Town & Country Planning Act 1990 (as amended)
Town & Country Planning (Tree Preservation) (England) Regulations 2012

Application No: FG/170/20/T
Site Address: Verge opposite 18a Ocean Drive The Poplars Ferring BN12 5GJ
Description of works: Various works to 6 No. Austrian Pine trees.

Plan showing location of trees

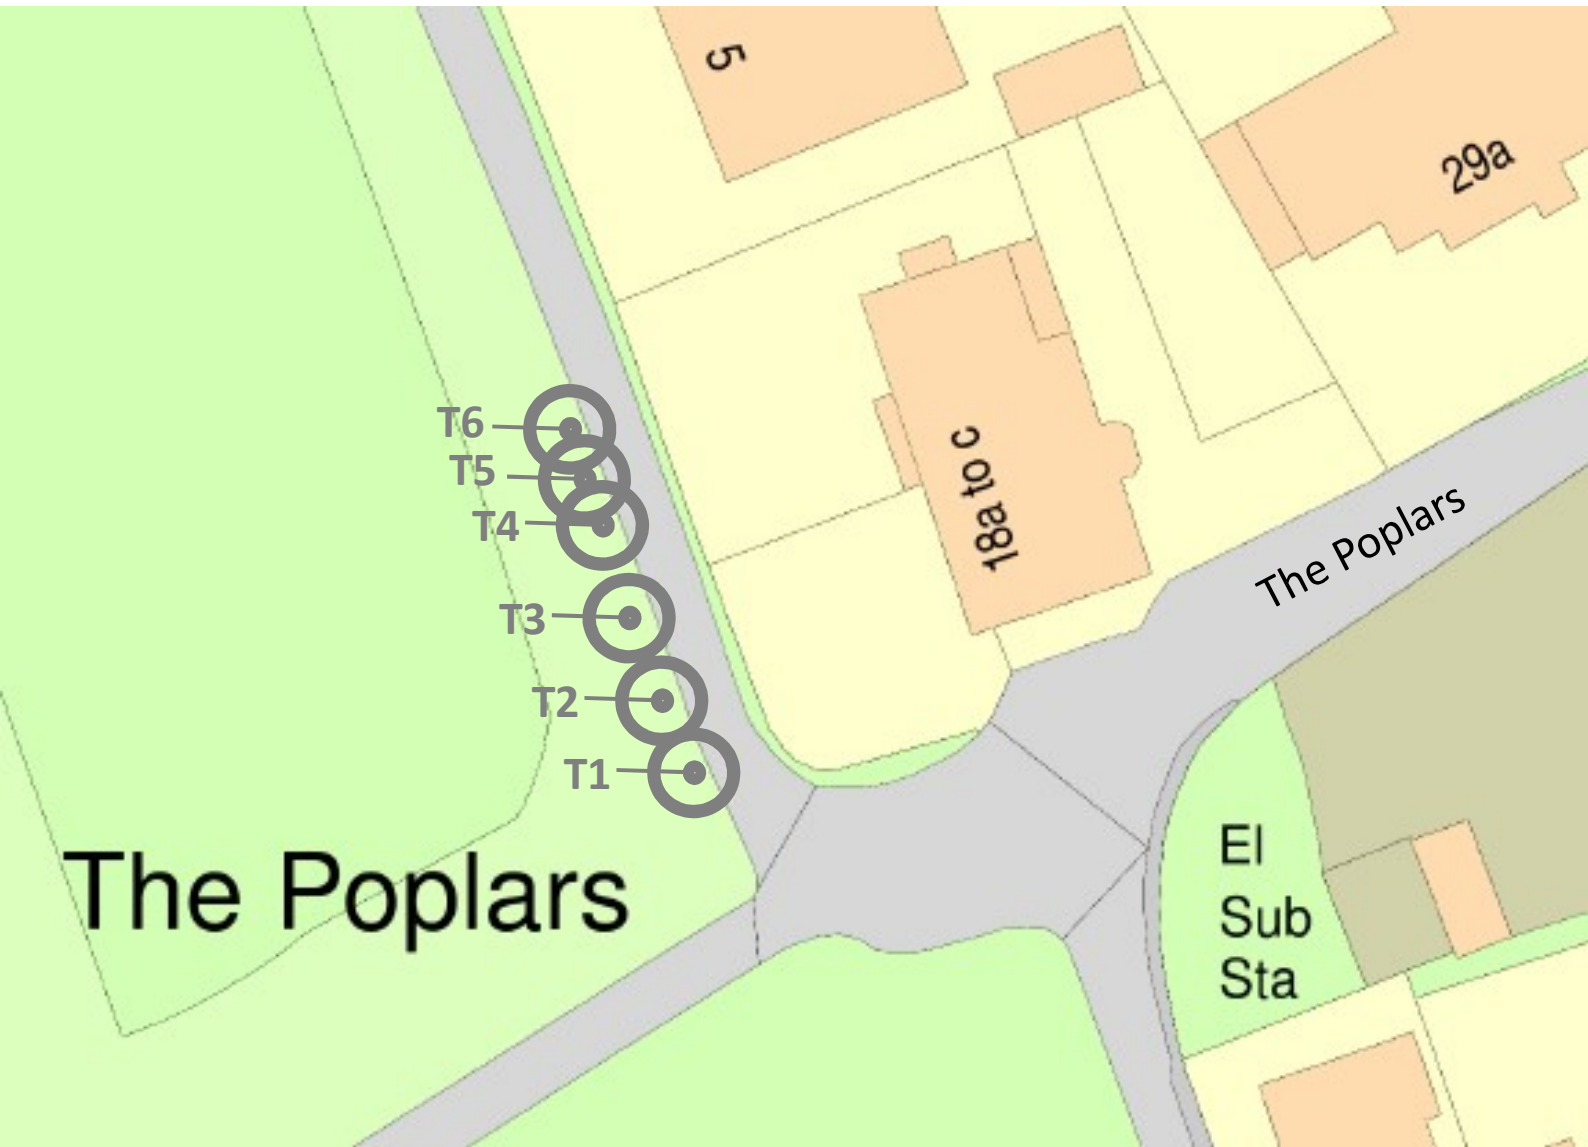
Ferring Conservation Group objects to the extreme treatment proposed for this important group of trees, which can be seen from, and character to, all of the Poplars Estate and the houses in Ocean Drive and West Drive.

The trees in the central garden area of the Poplars have been reduced in number and bulk over recent years, and some of them have been disfigured by excessive lopping. It would be a great pity to allow more trees to be damaged in this way - Ed Miller (Secretary, Ferring Conservation Group)
